Ribble Valley Borough Council

**App no: 24.0864**

**Address: Conkers Day Nursery, Dewhurst Road, Langho**

**Proposal: Change of use from day nursery (Use Class E (f)) to a mixed use including day nursery and education facility (sui generis).**

Revision
Project
Conkers Day Nursery
Address
**Dewsbury Rd,
Langho, BB6 8AF**
Client
Prosperity Children's Services
Drawing
Plans as Existing

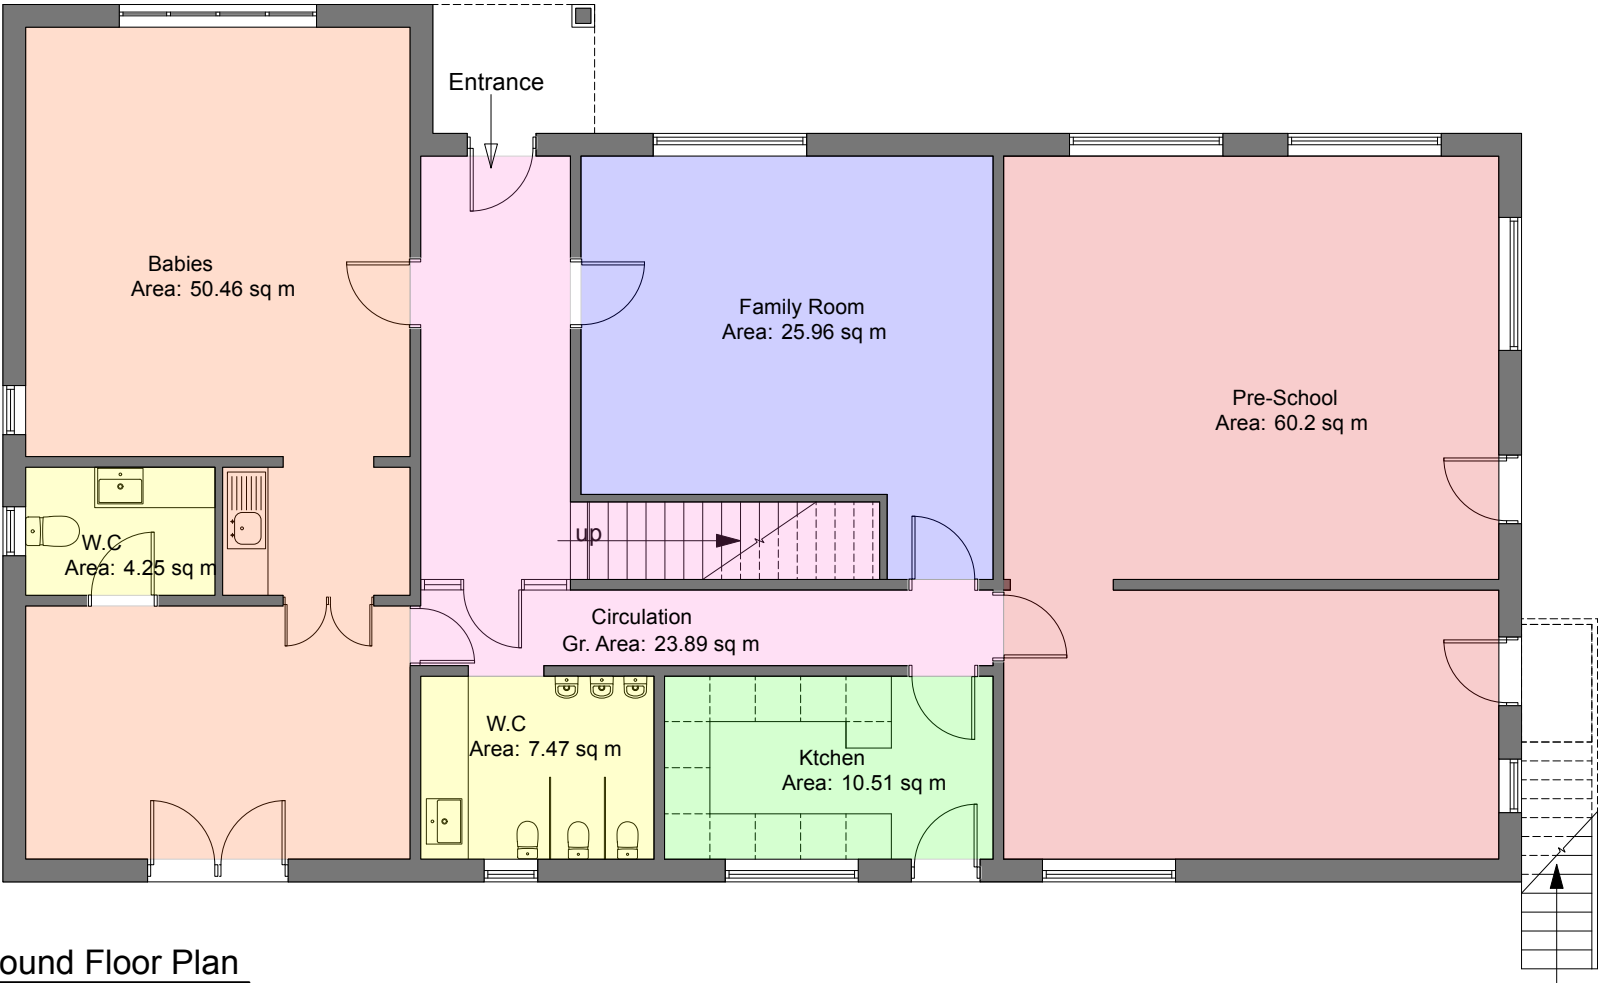
There are no changes to the existing parking provision proposed which shows 10 spaces marked out within an existing area of hardstanding adjacent to the Nursery.

As there is a combination of the two uses proposed, we would request that the number of children on site is provided with an analysis of the parking requirements based upon the standards to demonstrate that the existing provision is suitable.
